June 4, 2024

Re: Lexington Plantation

This department has reviewed the plan you submitted for the Lexington Plantation swimming pool to be constructed in Cameron, NC. This plan review was conducted in accordance with the current North Carolina Rules Governing Public Swimming Pools (15A NCAC 18A .2500). The plans have been approved with the following comments:

1 A1 POOL AND DECK PLAN
SCALE: 1/8" = 1'-0"

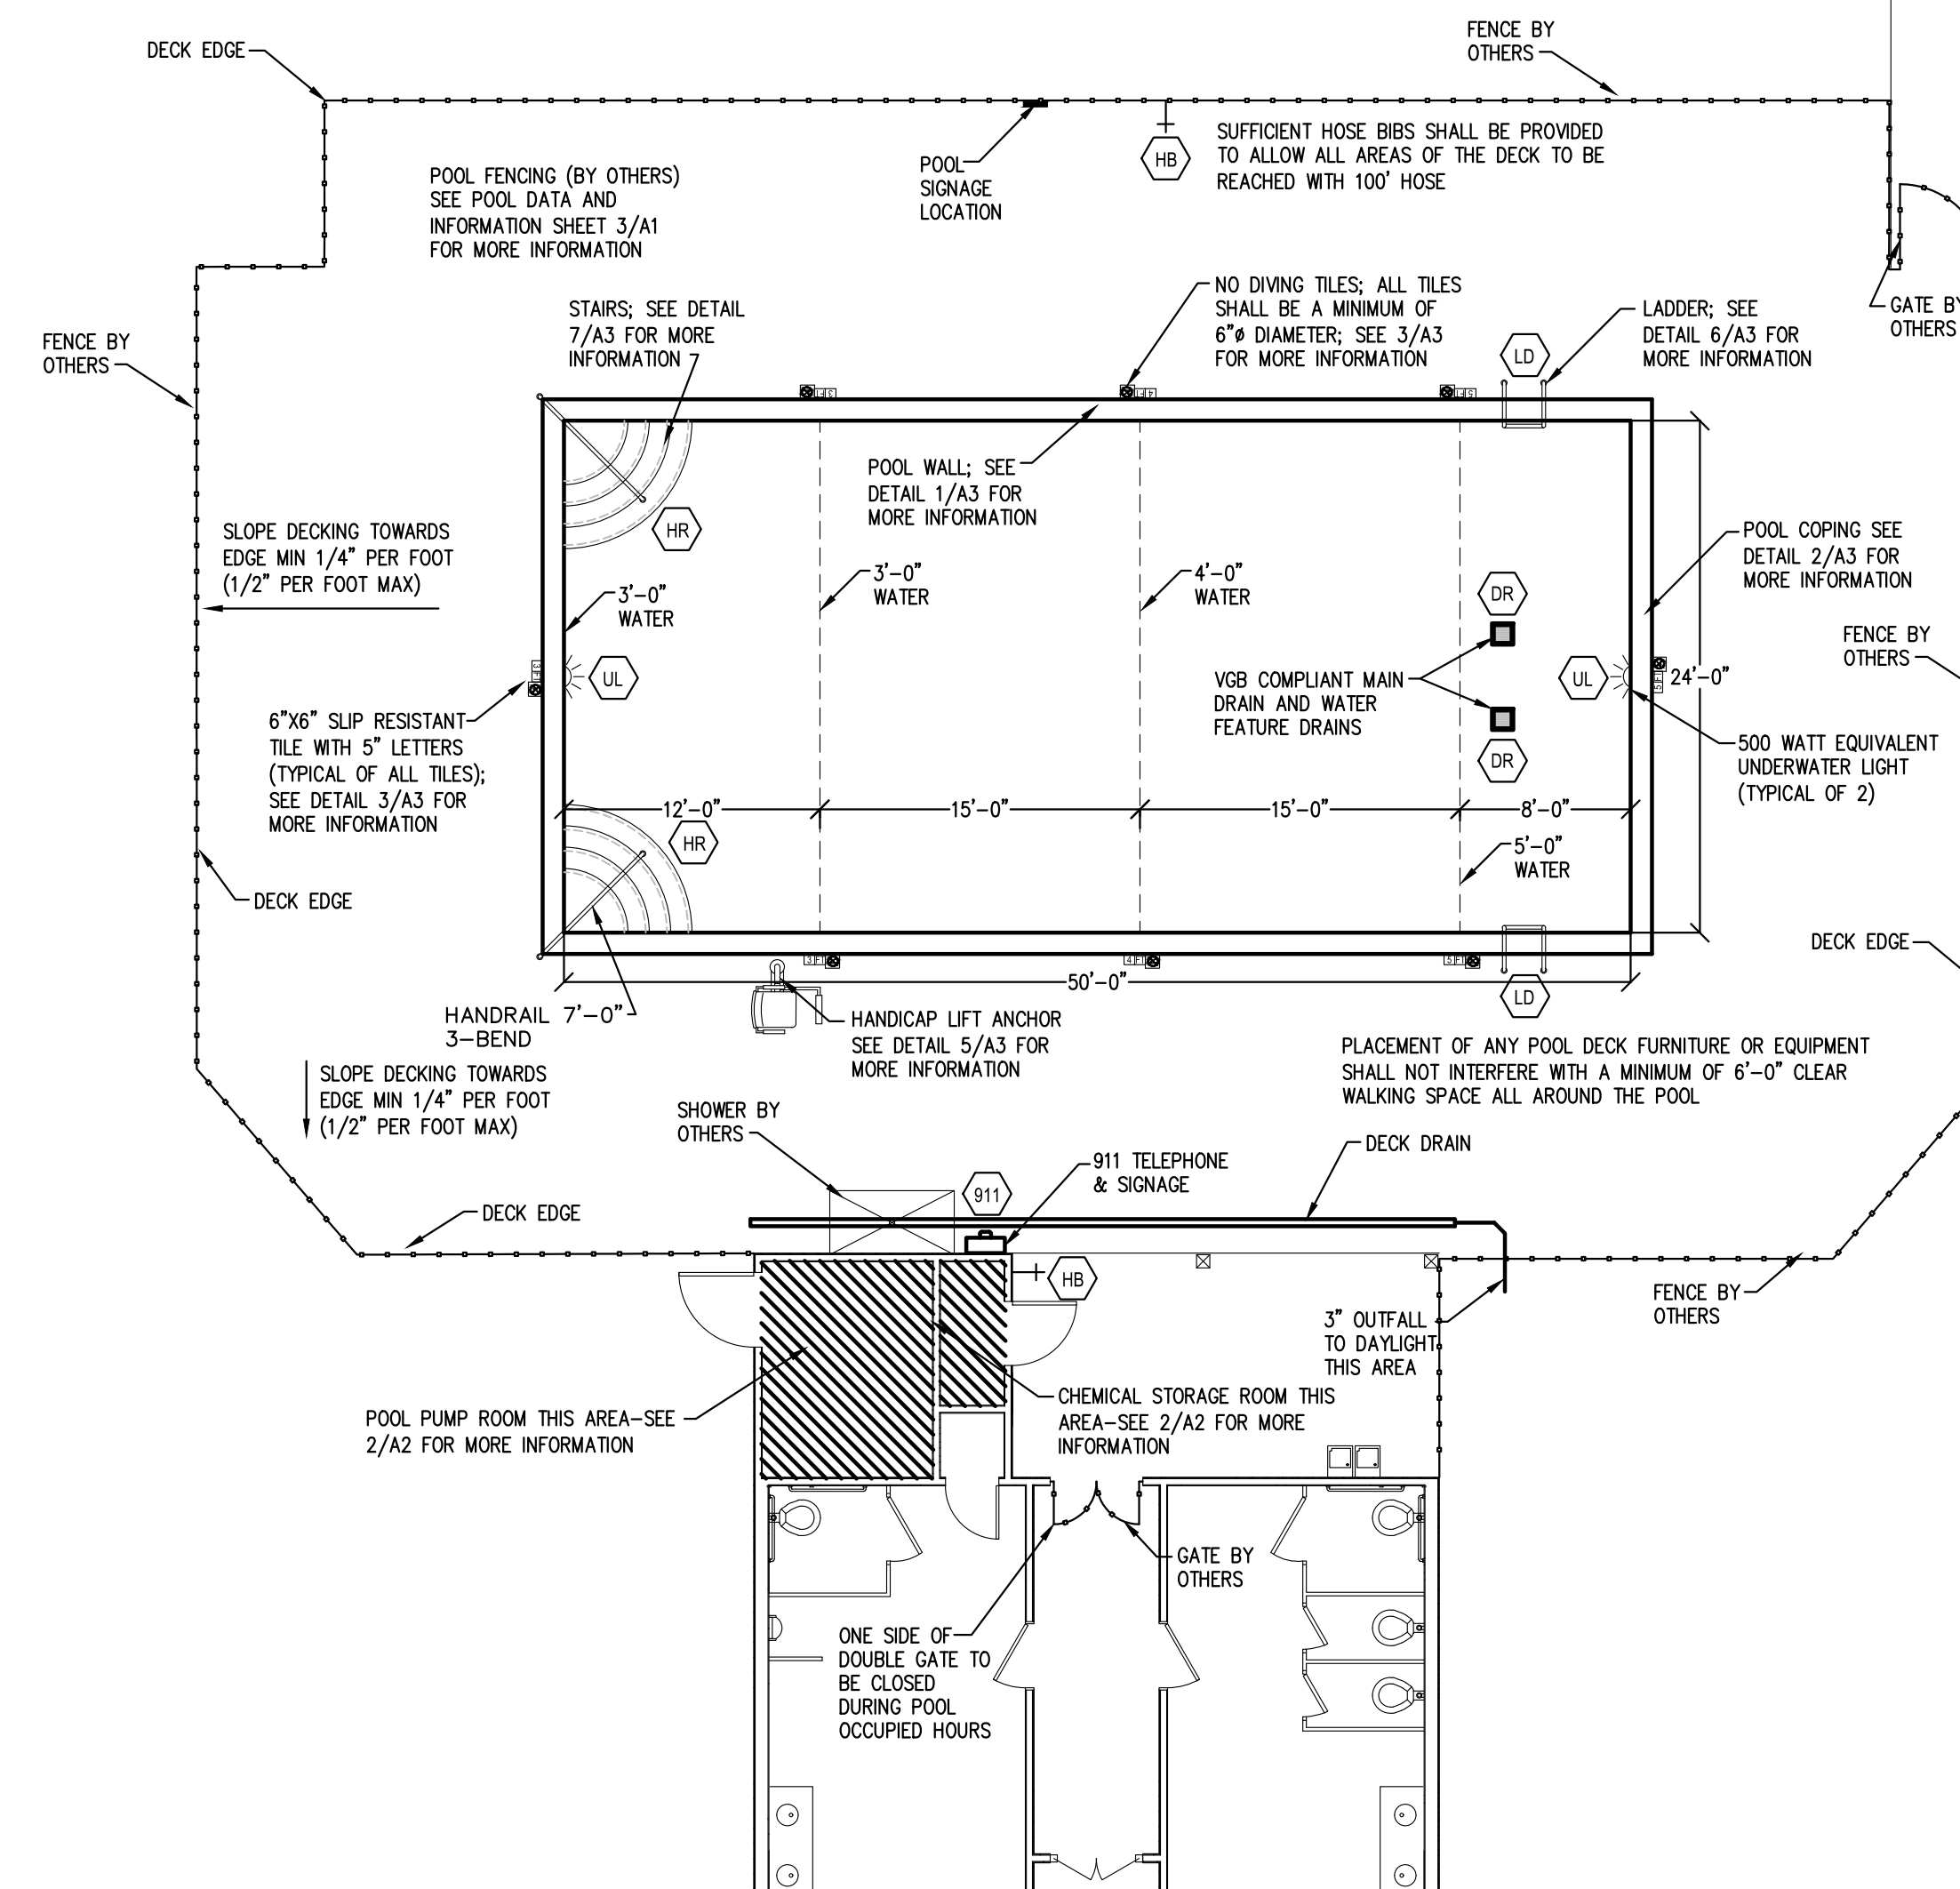
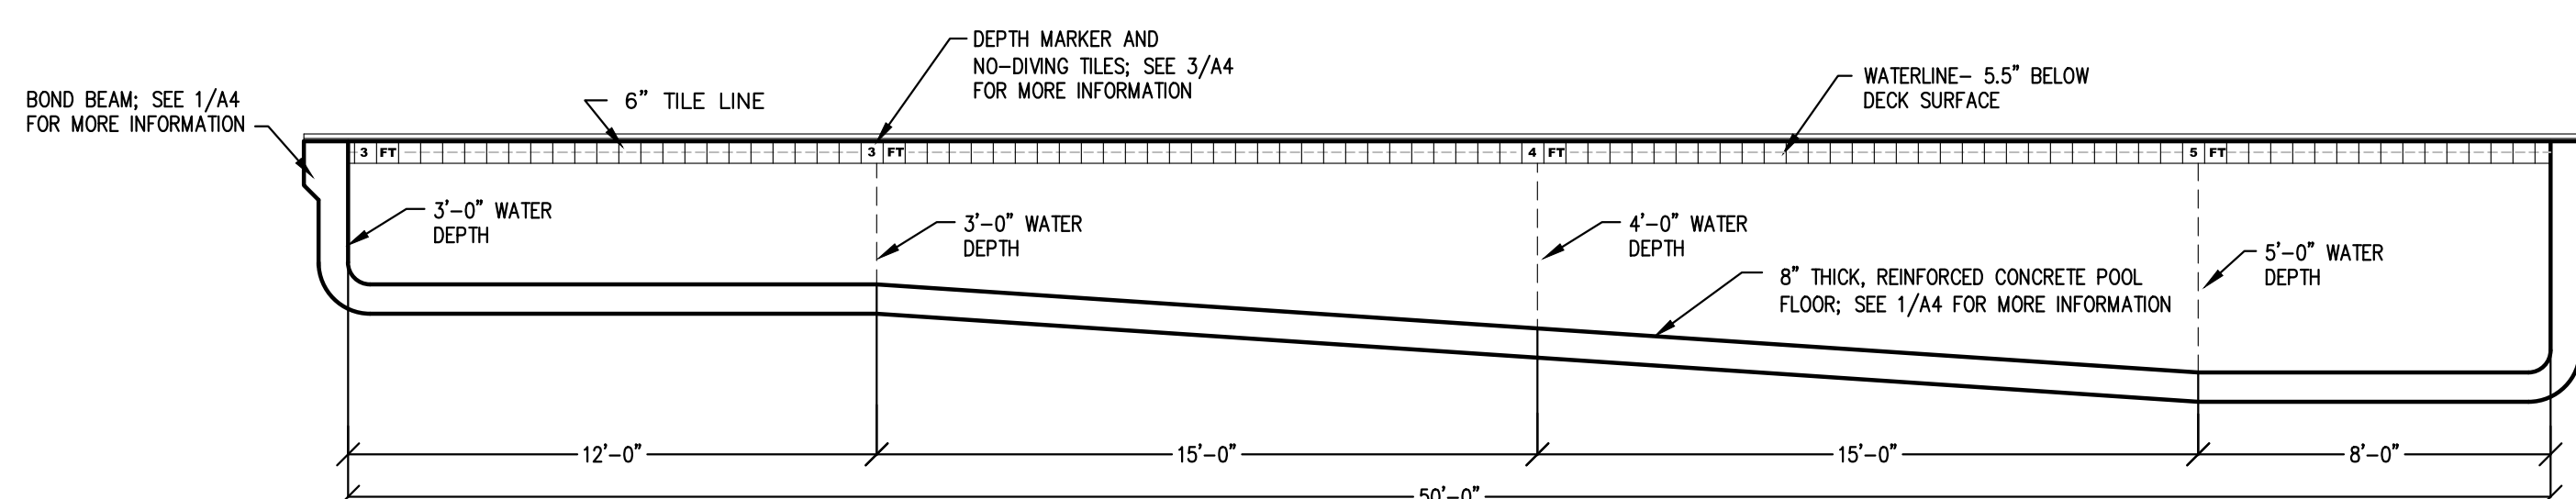
-The pool finish is indicated on the plans to be a smooth troweled finish. Per 15A NCAC 18A .2514(d) Pool surfaces in areas which are intended to provide footing for bathers including steps, ramps, and pool bottoms in areas with water less than three feet deep, shall be designed to provide a slip-resistant surface.

**ACCESSIBLE BATHROOM LAYOUT**

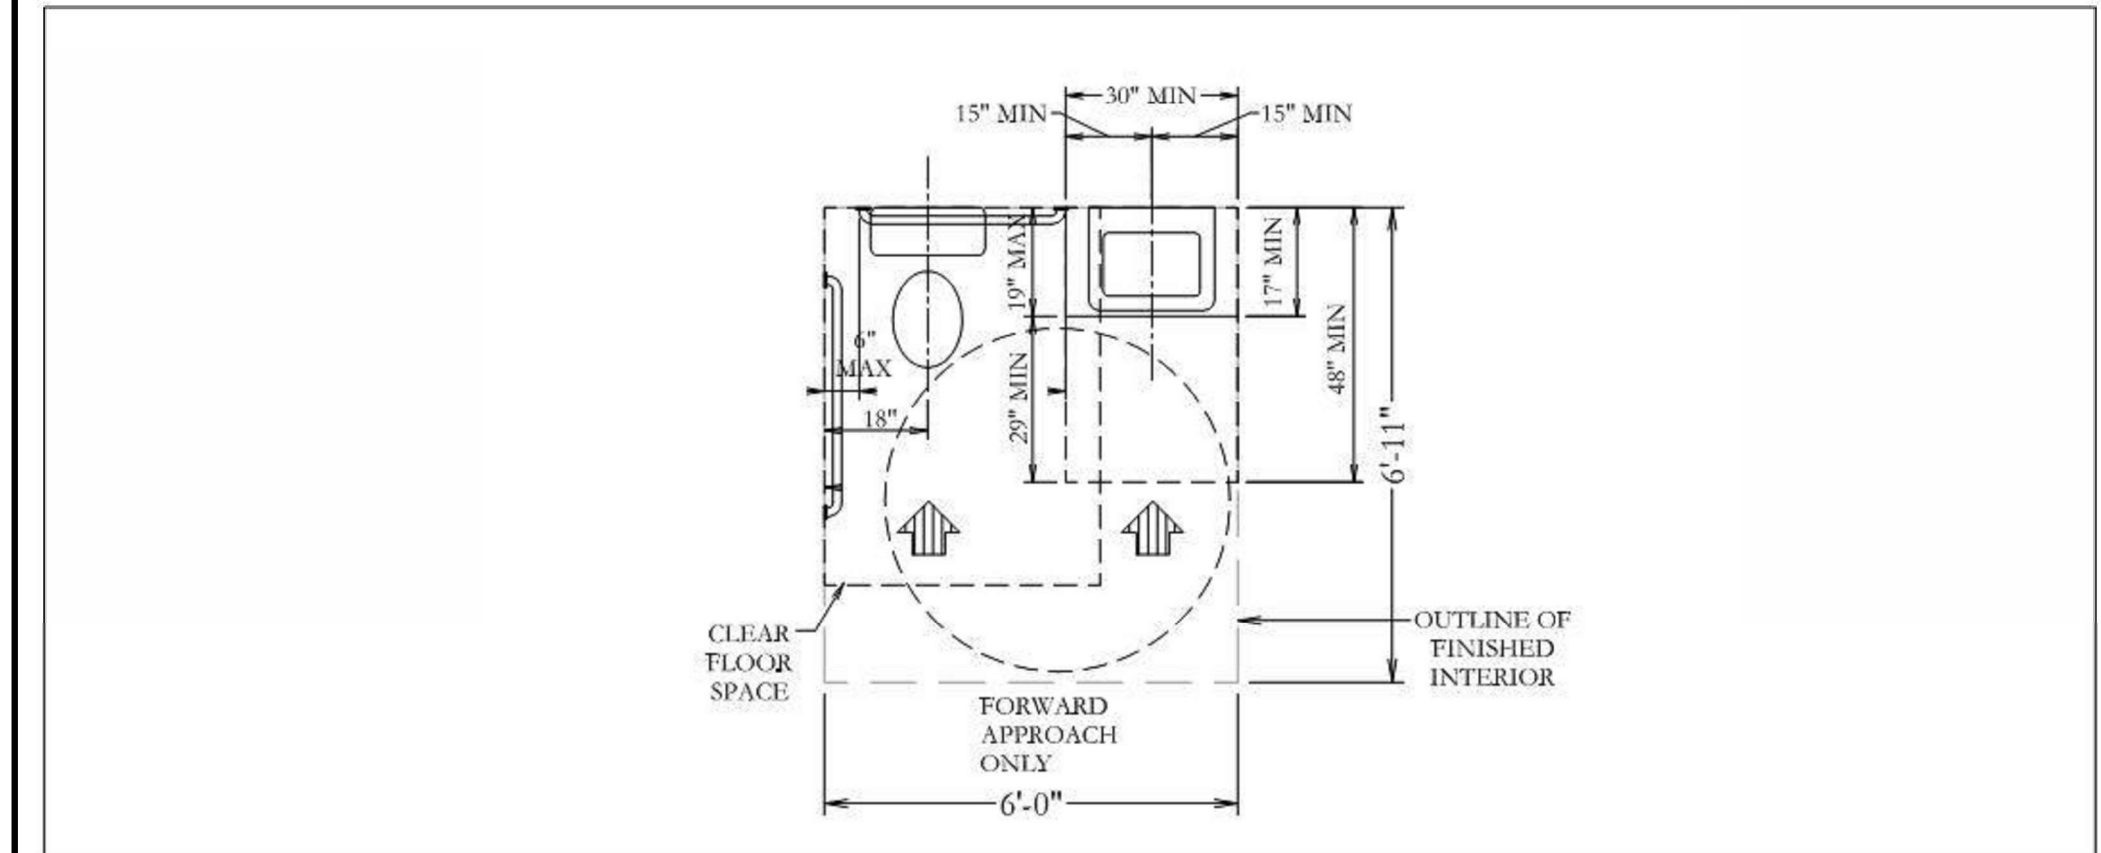
-Detail on the reference plans for the restroom facilities does not include a finish schedule or show partition construction. Per 15A NCAC 18A .2526(b) Partitions shall be of material, not subject to damage by water and shall be designed so that a waterway is provided between partitions and floor to permit thorough cleaning of the walls and floor areas with hoses and brooms. Also, per (c) of the same rule, Dressing facility floors shall be continuous throughout the areas. Floors shall have slip resistant surface that shall be smooth, to insure complete cleaning.
